**REF: TR020005**

**Gatwick Northern Runway Development Consent Order Application**

**CLARIFICATION QUESTIONS**

**Reigate & Banstead Borough Council**

APPENDIX 13.4.1  
FIGURE 4.1.6

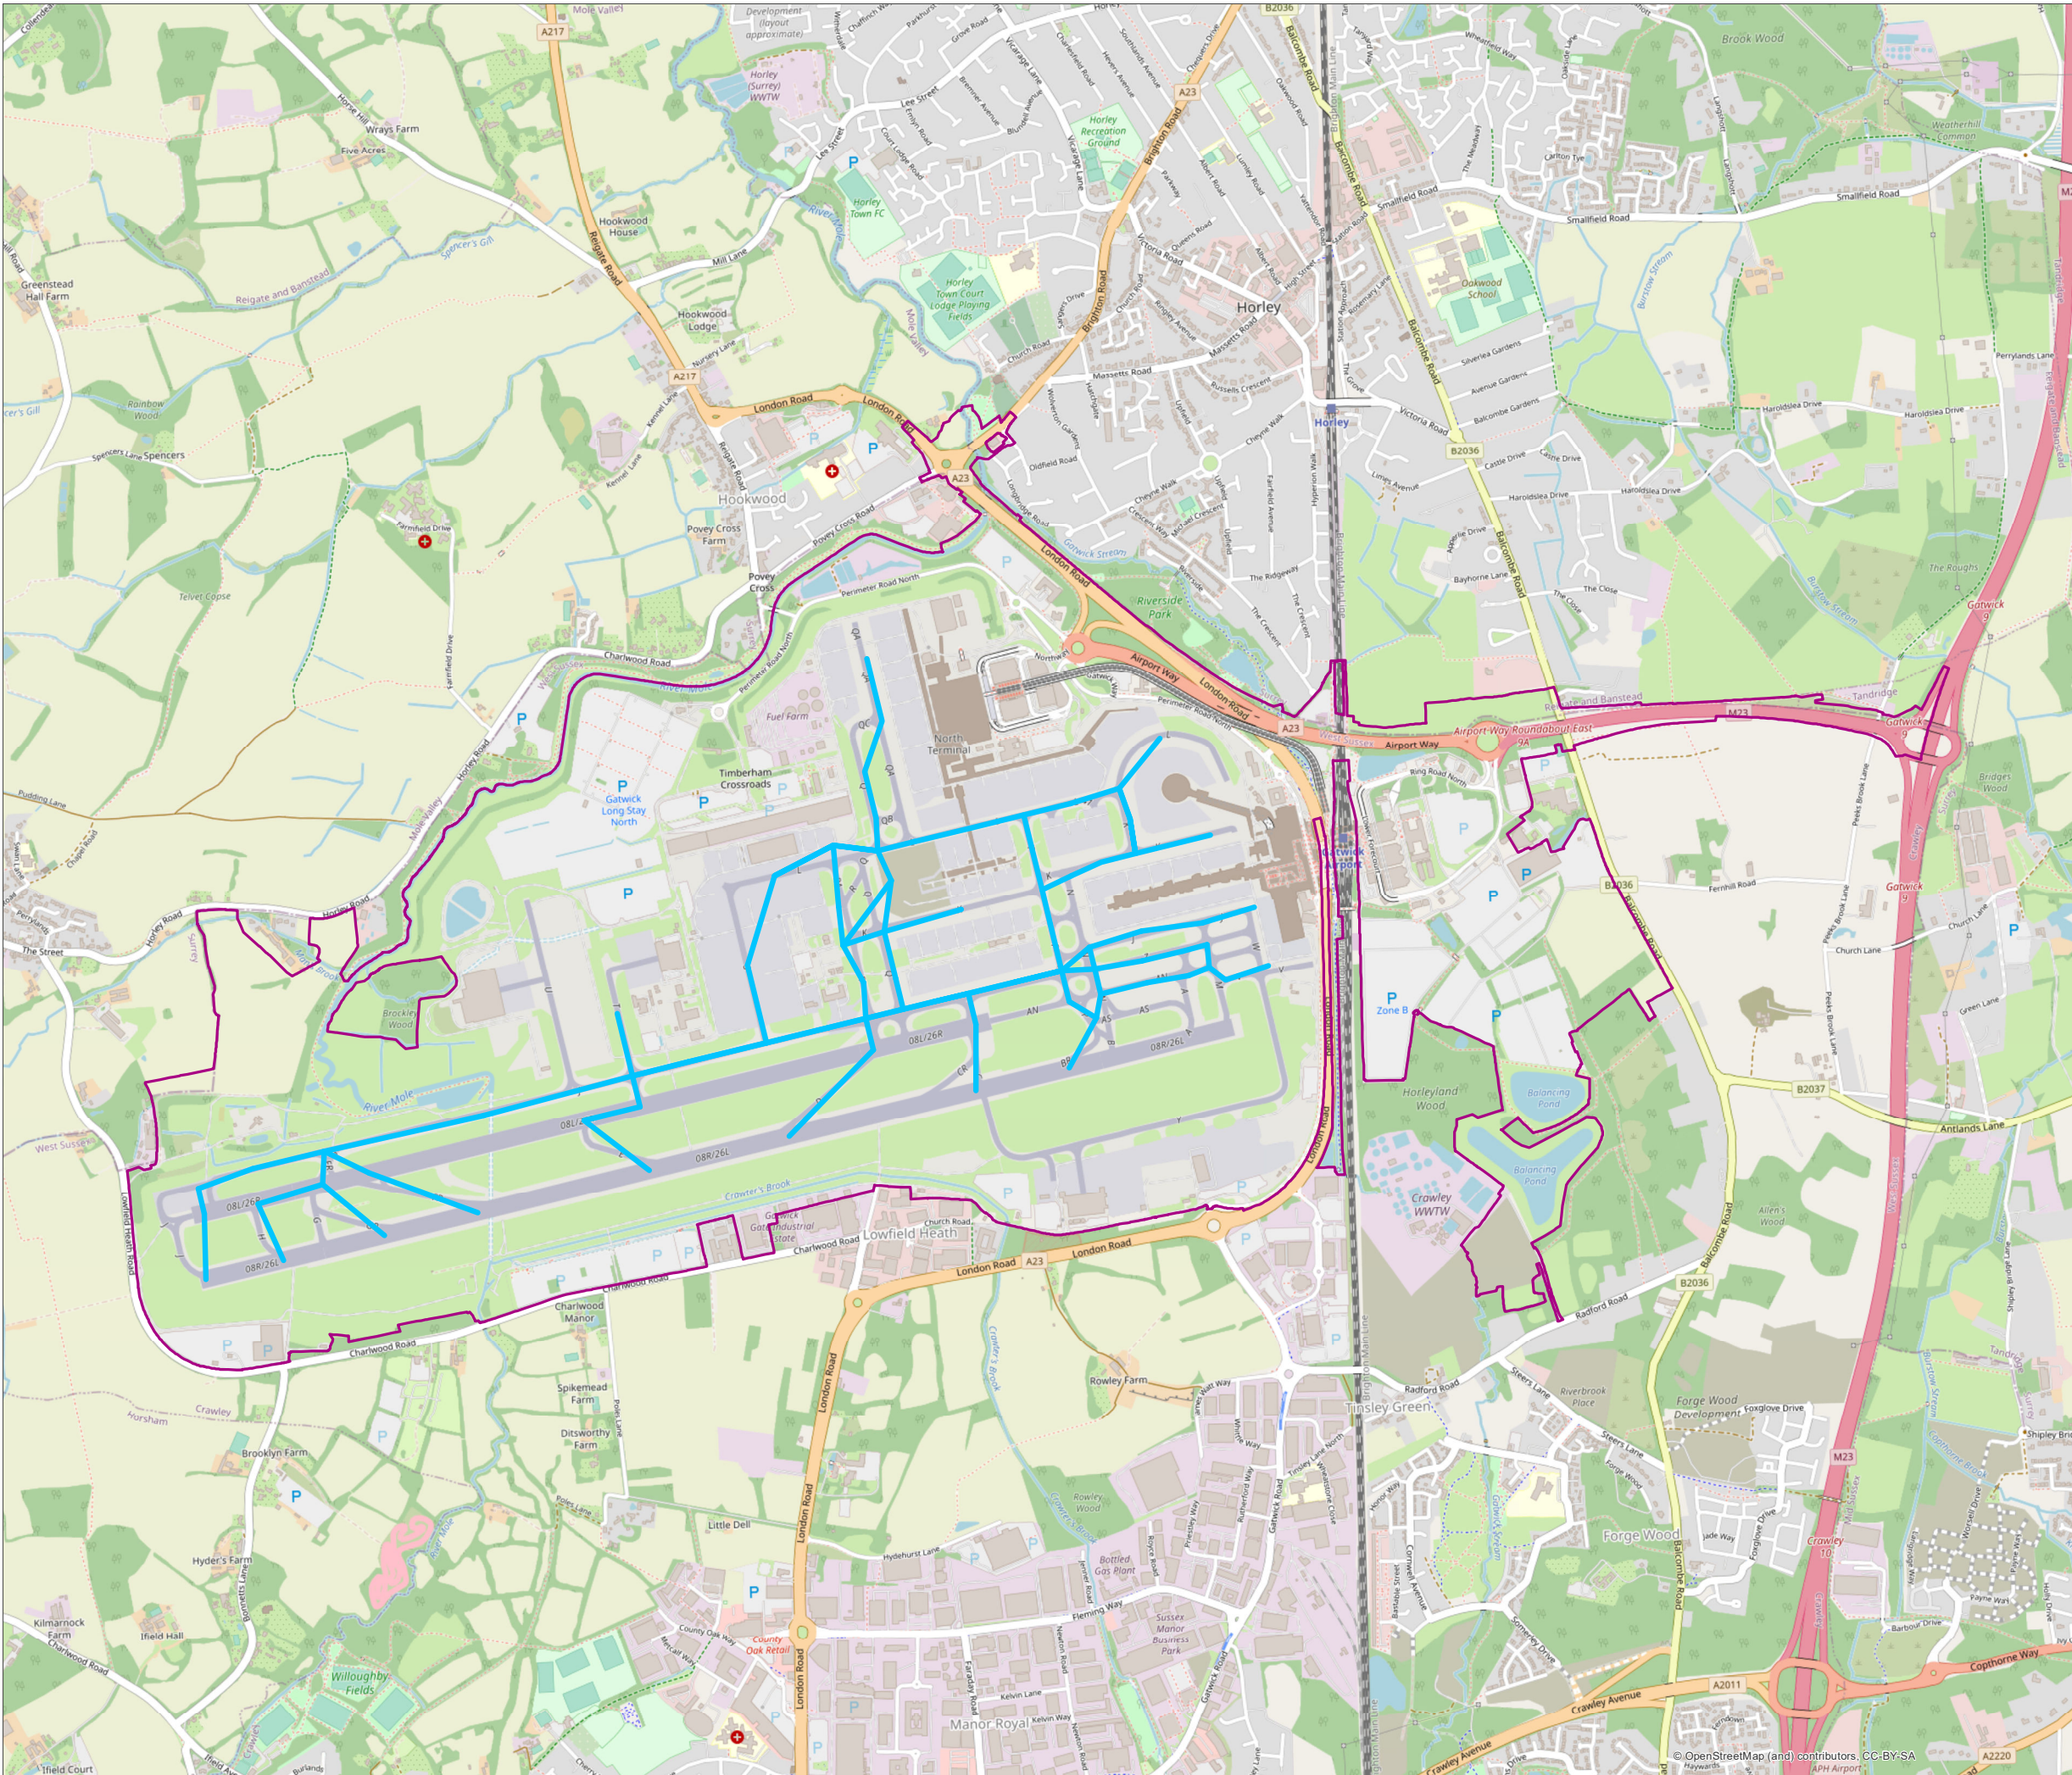
AQA5	Modelling	Has carpark Y been left off Figure 4.1.6 in appendix 13.4.1: Air Quality Figures Part 2?	Response to question.

DRAWING NO. <b>APPENDIX 13.4.1 FIGURE 4.1.15</b>	REVISION <b>For ES Issue</b>
	DRAWN BY <b>MA</b>	PM / CHECKED BY <b>AC</b>

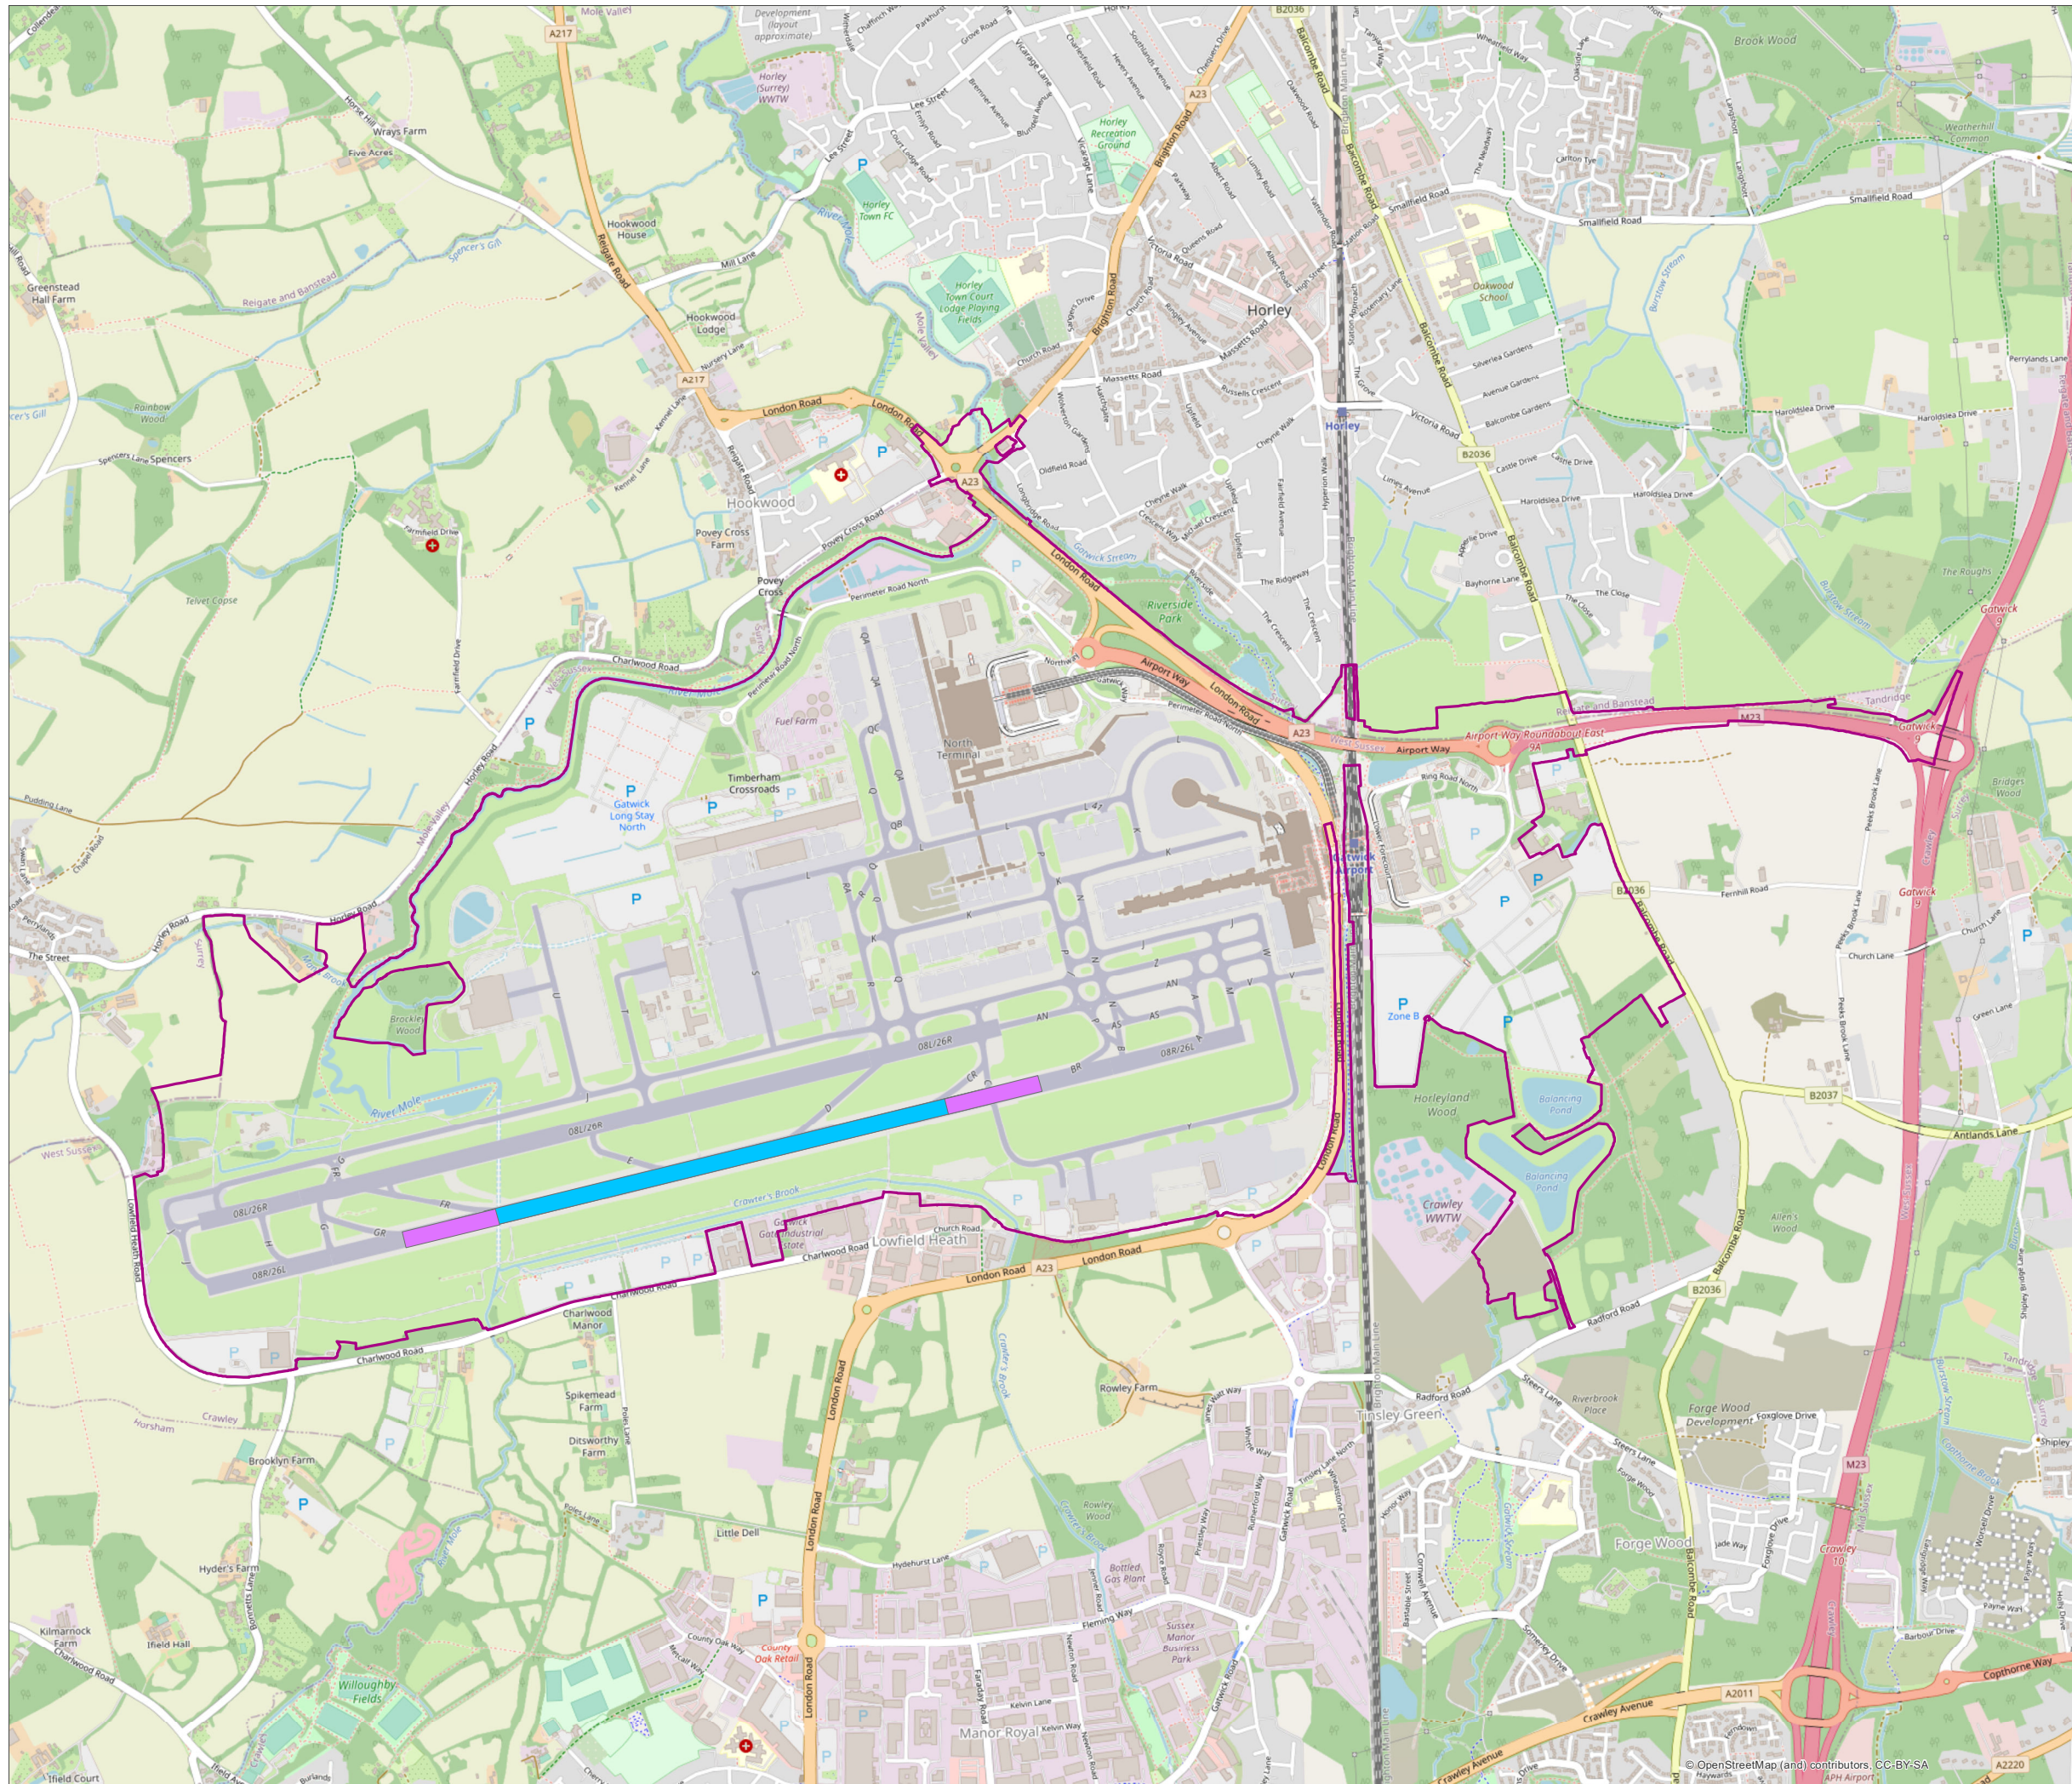
AQA6	Modelling	<p>What assumptions have been made in the modelling around landings on the northern runway? (Figure 4.1.15 Appendix 13.4.1 Air Quality Figures Part 2: Modelled LTO sources approach and landing).</p>	Response to question.	
AQA7	Modelling	<p>Appendix 13.6.1: Air Quality Data and Model verification is missing details on how model verification factors for the selected zones were established.</p> <p>Details are required of the initial verification including Monitored Road NOx Contribution versus Unverified Modelled Road NOx, which monitoring sites were used, and which were removed from the verification process.</p>	Provision of information.	
AQA8	Modelling	<p>Paragraph 13.7.15 describes that the background maps from Defra have been used in the air quality assessment, as well as the Defra Emissions Factors Toolkit, as described in paragraph 13.7.16 for scenarios after 2030. This provides a conservative assumption as the last available years for these scenarios is 2030 within these tools. However, there is no discussion on whether this is conservative for the 2024 and 2029 scenarios.</p> <p>The concern is that more recent years of assessment are not worst case.</p>	View on if background values are conservative for 2024 and 2029.
